RFI

RFI #: 61  
 Date: 2/22/2012  
 Job: EB-02 Keller Springs Lofts  
 Phone: 877-777-5115

CC: David Gallagher (Embrey Builders LLC)  
 Subject: Fire Extinguisher Cabinets Locations

RFI #: 176  
 Date: 8/2/2012  
 Job: EB-02 Keller Springs Lofts  
 Phone: 877-777-5115

SHEET NUMBER
3.2A
BLDG PLAN 'A'

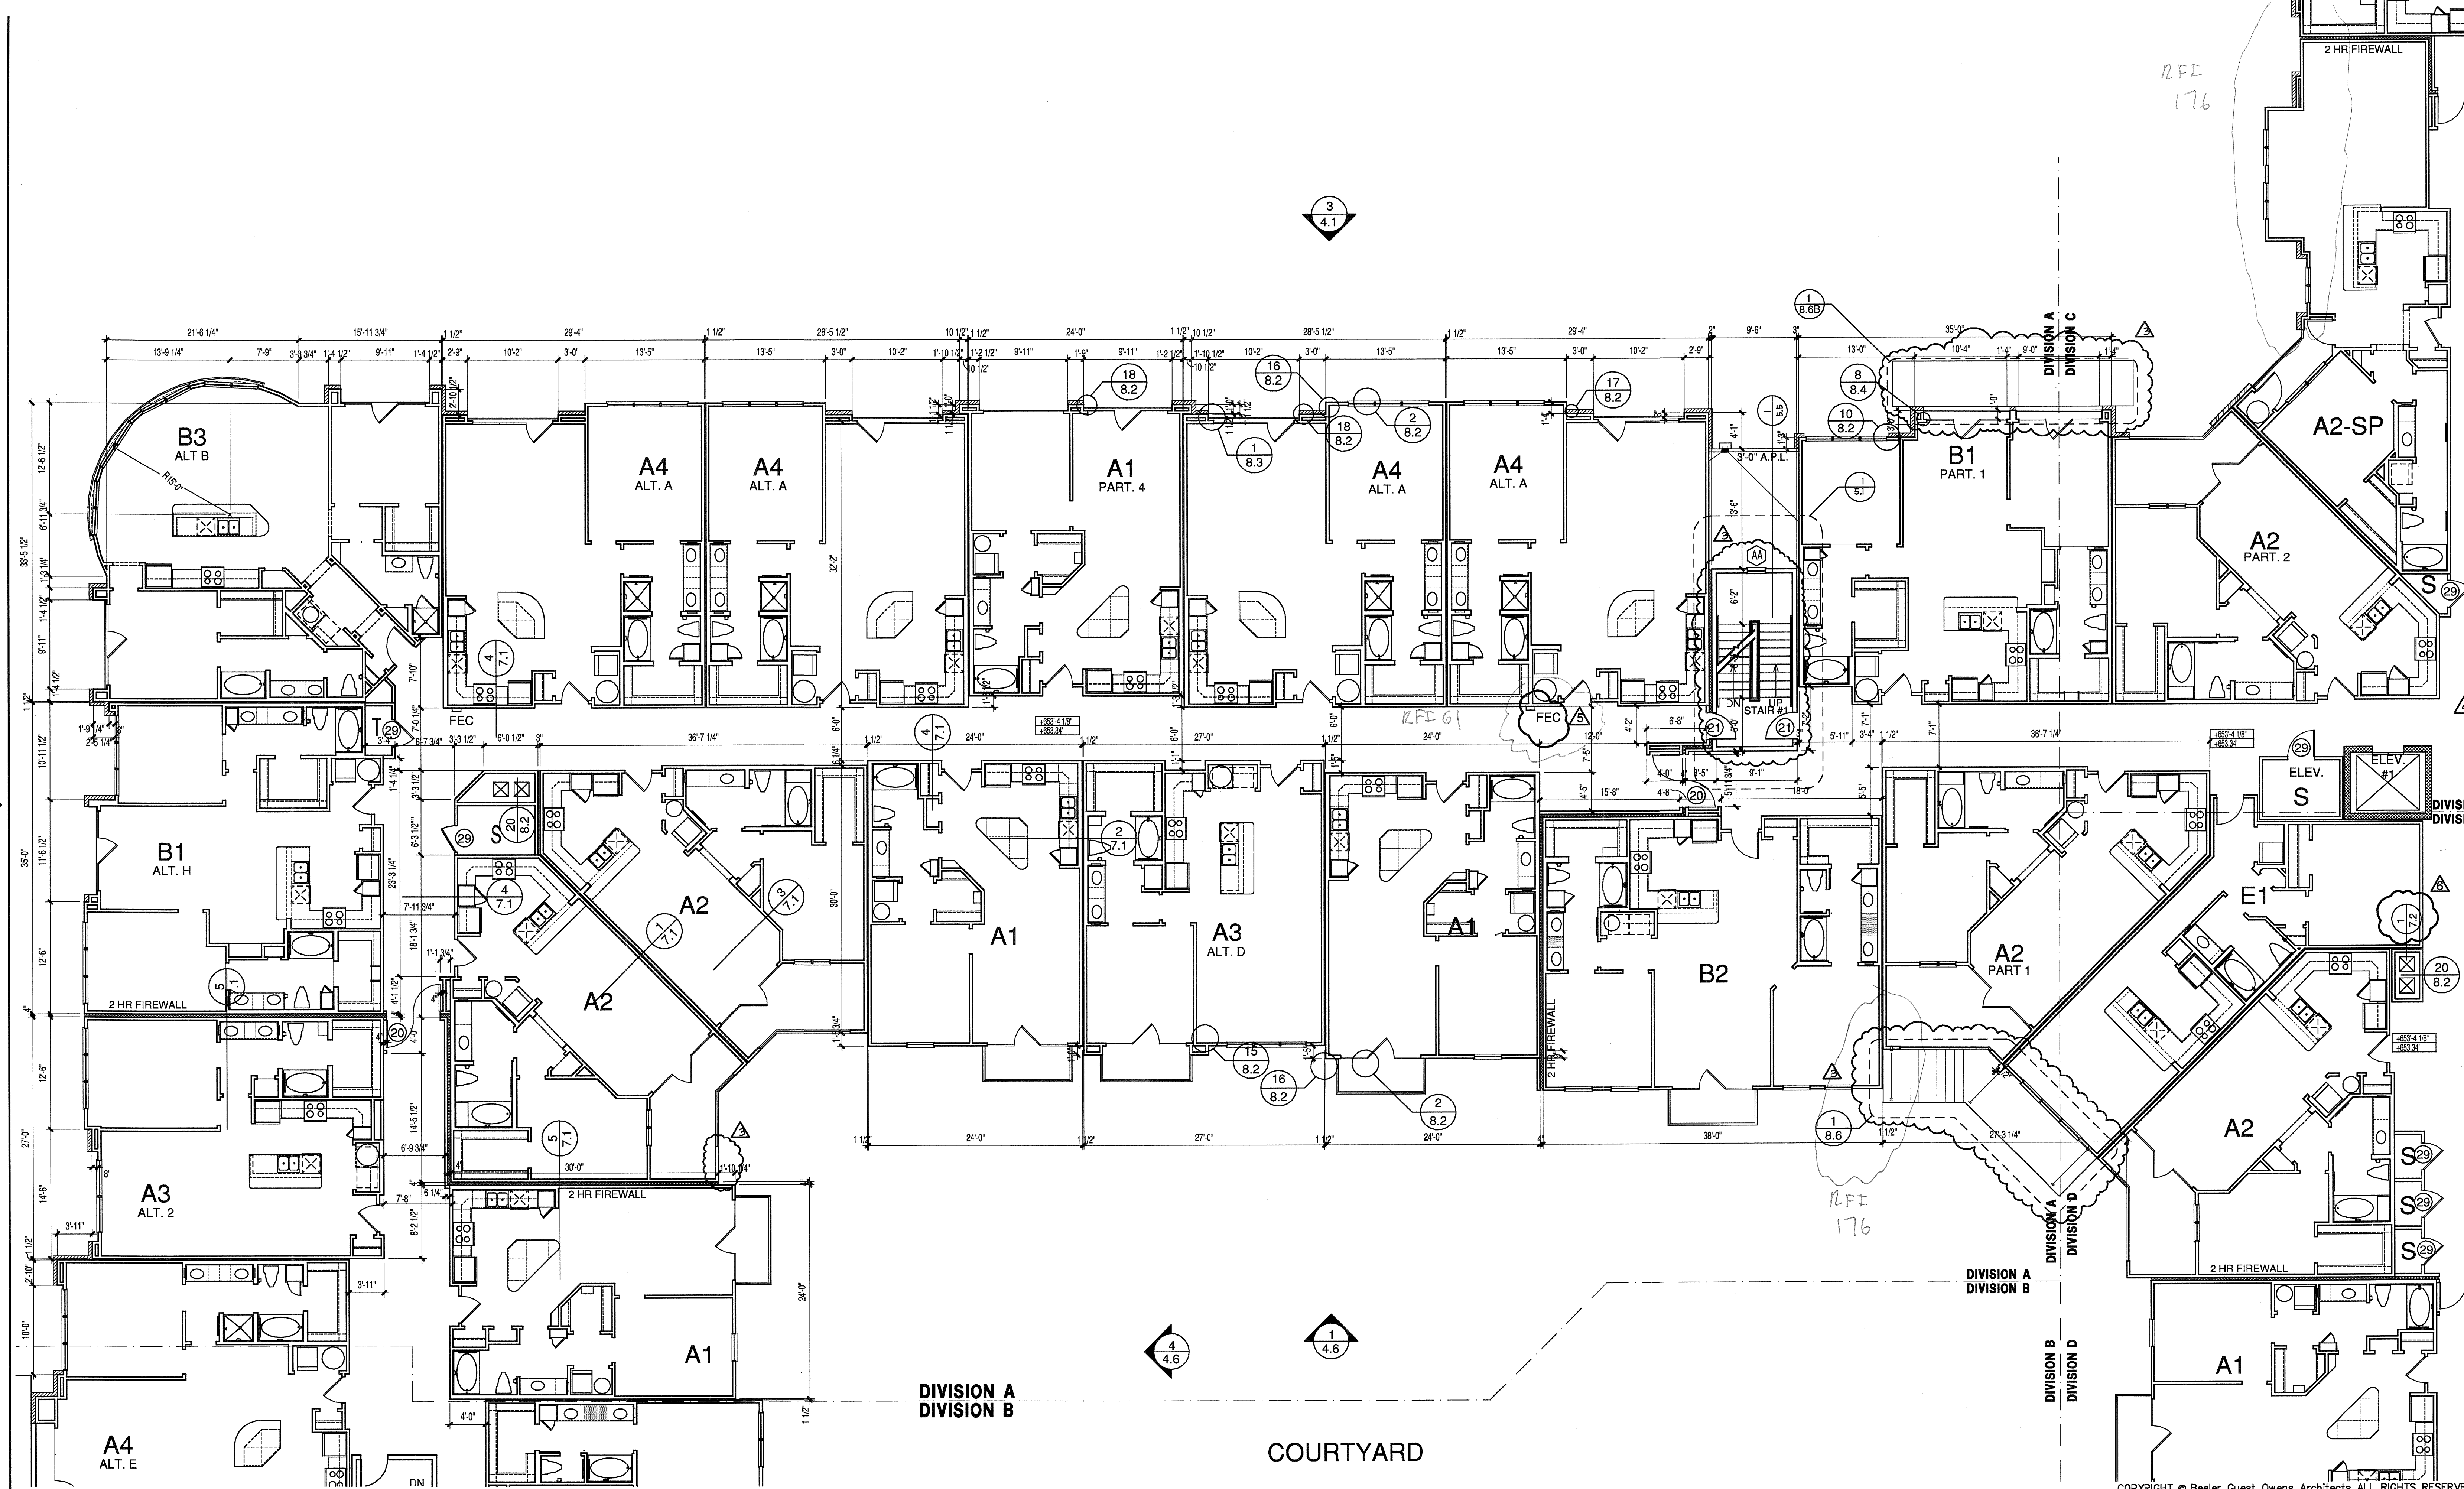
**Request:** Date Required: 2/29/2012  
 1) There are some inconsistencies with plans for FEC locations in corridors.  
 3.1A shows 2 FEC  
 3.2A shows 1 FEC  
 3.3A shows 1 FEC  
 3.4A shows 2 FEC  
 Do you want 2nd FEC added for 2nd & 3rd floors?  
 2) On sheet 3.4F - FEC mark is missing on A4 All G wall.  
 The FEC is shown on 1st, 2nd and 3rd floors, does the FEC need to be included at 4th floor?  
 Please verify all sections for coordination and consistency.  
 3) Do we need fire extinguishers in club/leasing? We have assumed 1 for club and 1 for leasing.  
 4) Do we need FE in parking garage and if so what type of mounting?

**Request:** Date Required: 8/2/2012  
 On sheet 3.2A the highlighted wall between the B2 unit and the stair tower is 5'-12" past the steel. Our conversation on site please specify what size angle to weld to beam and install 2x10 or 2x12 to support the wall. Please provide gusset detail to support the areas highlighted on the A2-SP unit per our conversation onsite, and per the attached sketches.

**Response:**  
 1- Yes.  
 2- Yes. I've checked all locations and the one's you mentioned are the only problem locations. I adjusted 2 other FEC locations by moving them a foot or so now all FECs line up in the same spot from floor to floor (except for the Club and Garage areas).  
 3- I've placed the 2 FECs you mentioned in sheet 9.1  
 4- Yes, we need them in the parking garage. I've updated the sheets to reflect this. Double check with your local Fire Marshall, but I'm confident that a surface mounting will be fine.

**Response:**  
 See attached details.
